From: Anita Gardner
Sent: 13 June 2022 15:58
To: [REDACTED]
Subject: FW: F/5/22/DOC Wicks Farm Ford FIR

From: Place Services Ecology [REDACTED]
Sent: 13 June 2022 11:48
To: Planning.Responses <Planning.Responses@arun.gov.uk>; Anita Gardner <Anita.Gardner@arun.gov.uk>
Cc: Sue Hooton - Principal Ecological Consultant [REDACTED]
Subject: F/5/22/DOC Wicks Farm Ford FIR

Application: F/5/22/DOC
Location: Wicks Farm Ford Lane Ford BN18 0DF
Proposal: Approval of details reserved by condition imposed under F/7/21/PL relating to conditions 3-surface water drainage scheme, 4-discharge of flows to watercourses, 5-maintenance and management of surface water drainage, 6-landscape screening scheme, 7-contamination and 9-ecological enhancements.

TITLE Proposed Site Layout Plan
 14/06/2022
 SCALE 1:2000 @ A3
 PROJECT No. 23482
 REPORT TYPE
 DATE 03

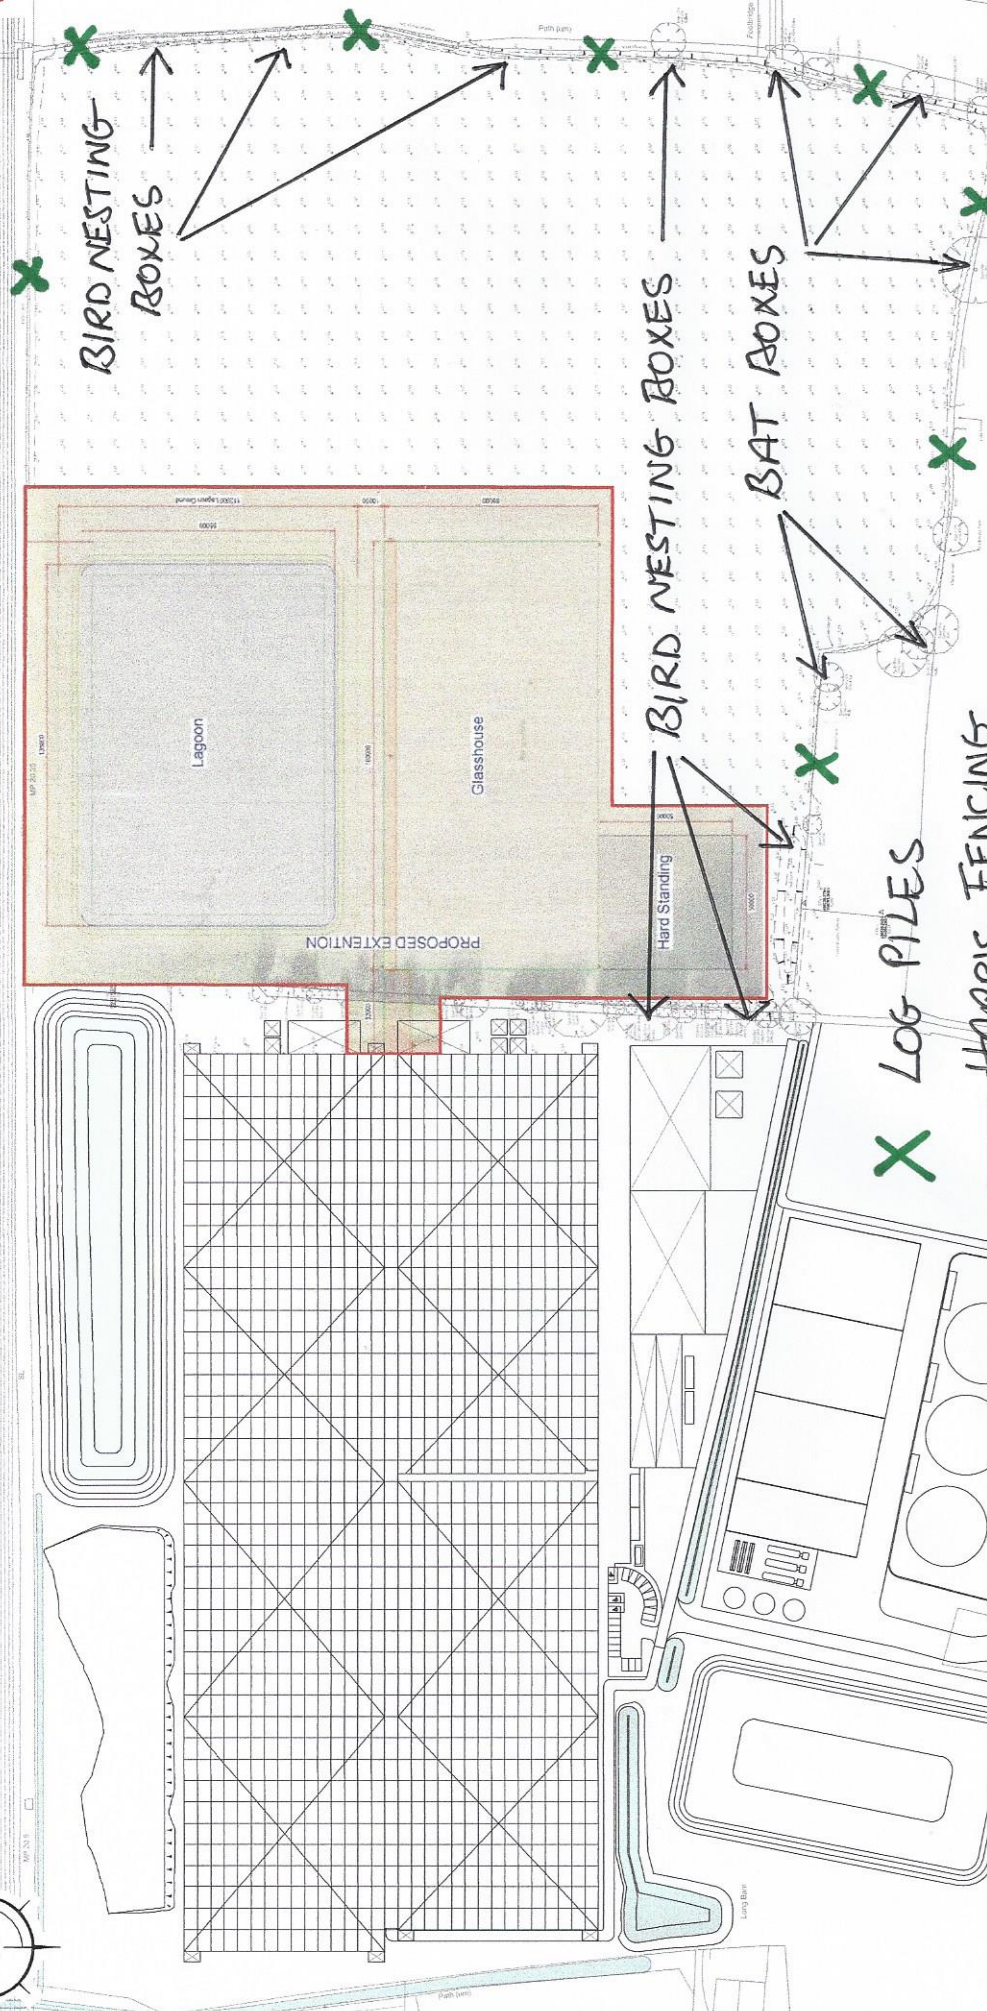
With regard to Condition 9, please can you confirm to John Hall Consulting Ltd., that a plan of the locations of the Harris fencing, bird and bat boxes and log piles is required, as suggested in the letter attached to the above application.

Please can you also request that the design of the bat and bird boxes is confirmed as required by Condition 9:

- *Position and design of a bat box to be installed on the trees onsite facing south/south westerly positioned 3-5m above ground.*
- *Position and design of a bird box to be installed on a tree on the site.*
